CITY OF ALBUQUERQUE

**Re: French's (TLC)
2401 Edith Blvd NE
Grading and Drainage
Engineers Stamp Date 3/2/2015 (H15D058)**

**Re: French's (TLC)
2401 Edith Blvd NE
Grading and Drainage
Engineers Stamp Date 2/2/2015 (H15D058)**

GRADING & DRAINAGE PLAN

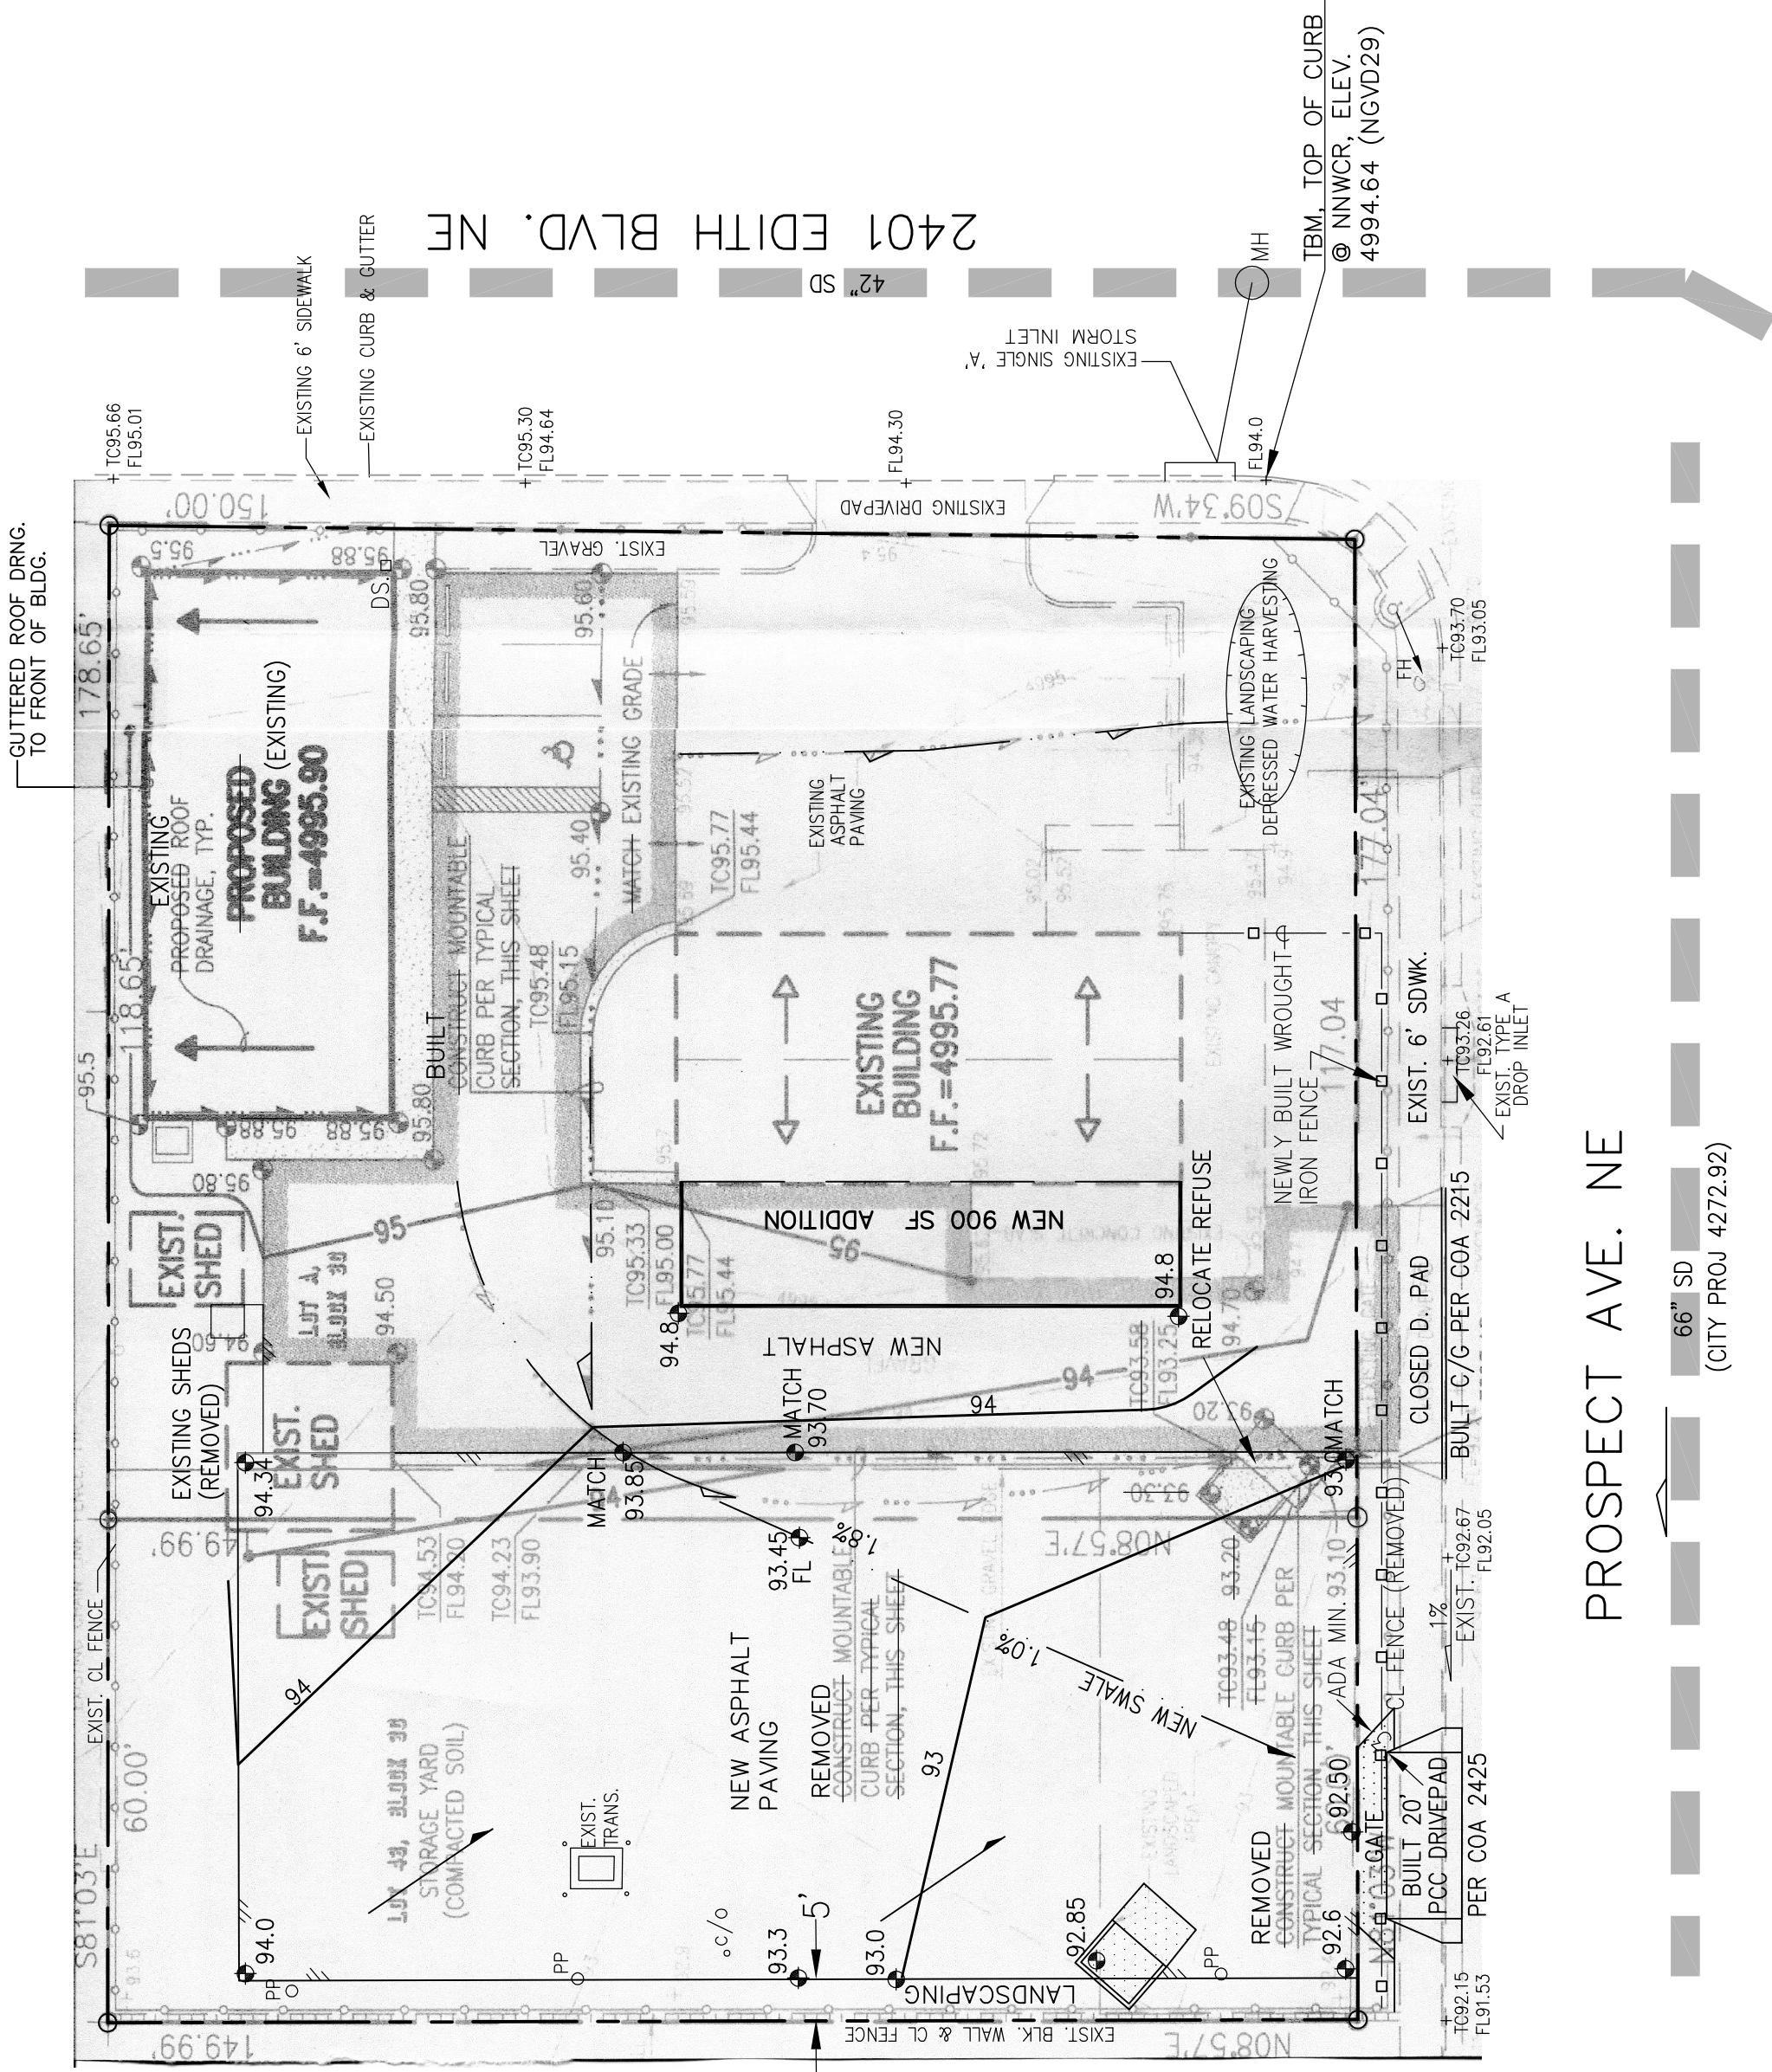
- Mention of the "First Flush" for the new impervious area needs to be on this plan.
- The new impervious area must flow through a retention pond before leaving the site for "First Flush" purposes. The amount which should be provided for the "First Flush" is, .34 times the impervious area. It appears that the new asphalt paving can drain to the west into the landscape buffer then head south via an earthen swale, then leave the site by sidewalk culvert or out the drive pad.
